Our ref: NO/2022/114950/02-L01
Your ref: 3/2022/1003
Date: 26 January 2023

**DISCHARGE OF CONDITION 21 (COMPENSATORY STORAGE) FROM PLANNING
PERMISSION 3/2021/0205.
LAND AT NEDDY LANE, BILLINGTON, BB7 9LL**

SECTION LOW FLOW CHANNEL

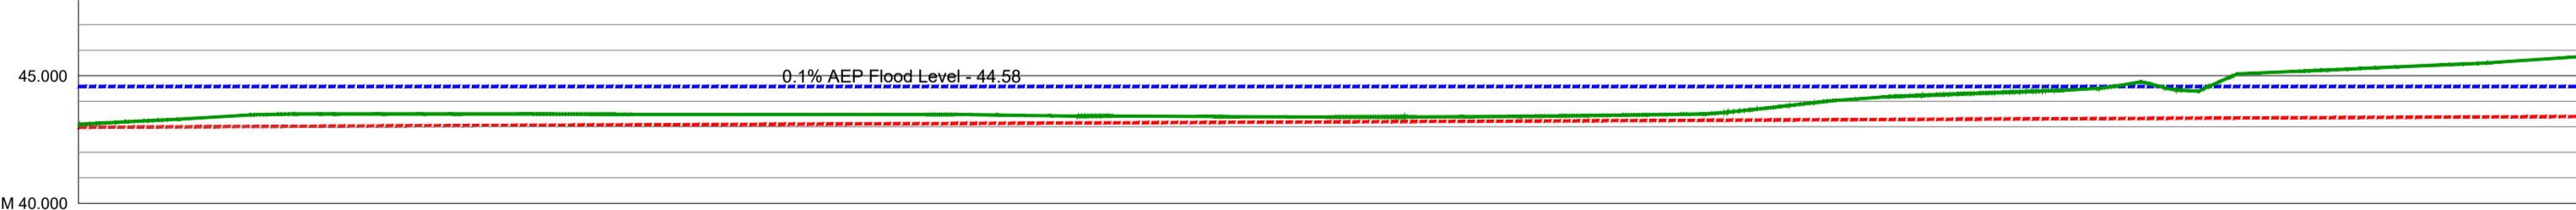
An additional "General Arrangement" drawing dated January 2023 has been submitted with the most recent application. Unfortunately, this drawing does no more than provide some updates to the design, principally the inclusion of a low flow channel which will, we assume, assist in drain down. Other than this and some additional annotation, there is insufficient information to enable us to alter our previous position. Therefore, we currently do not recommend the discharge of condition 21 until further information is supplied by the applicant.
